Johnston Property Management
Milton & Joan Johnston
1211 Vuecrest
Ellensburg, Wa 98926
899-2756
Email: miltonjohnston@charter.net

March 31, 2014

Reference: Helena Substation CU-13-00008

**A3**

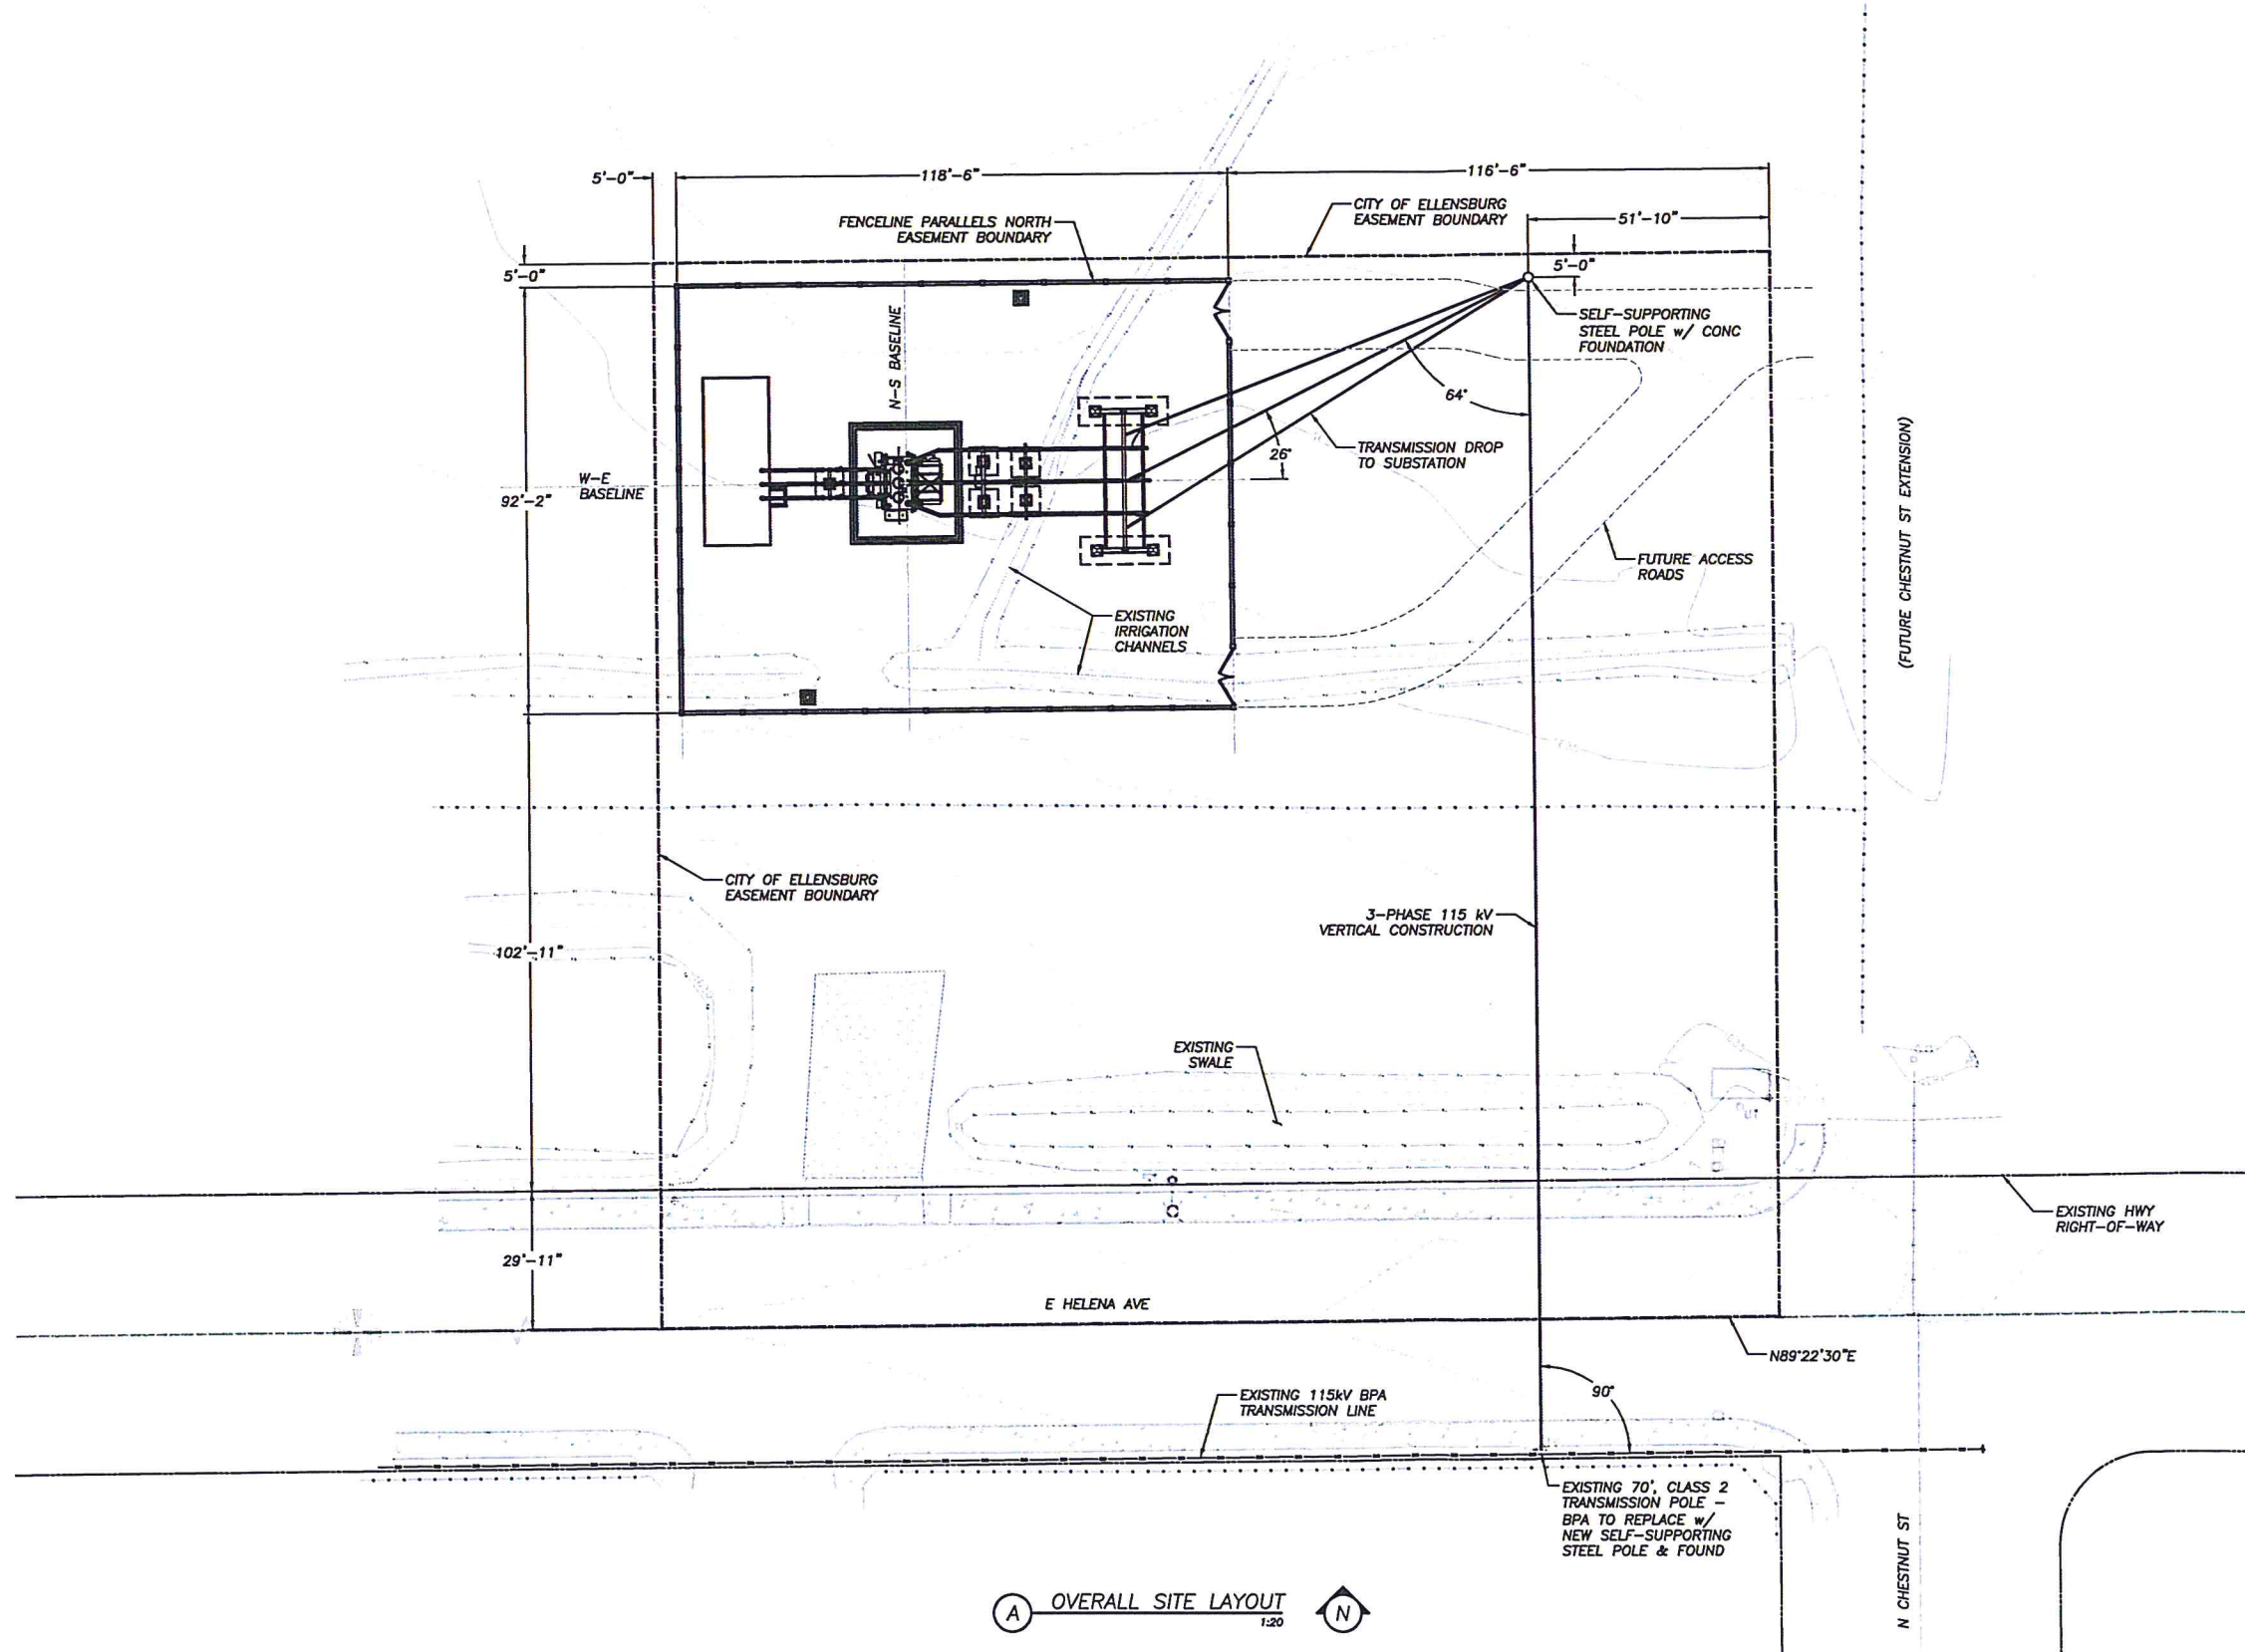
For these reasons I am opposing the siting of the substation in this particular location. If it must be located in this area, then significant perimeter barriers should be constructed to shield the substation from the surrounding areas. It also should be sited further north so it is not directly next to Helena.
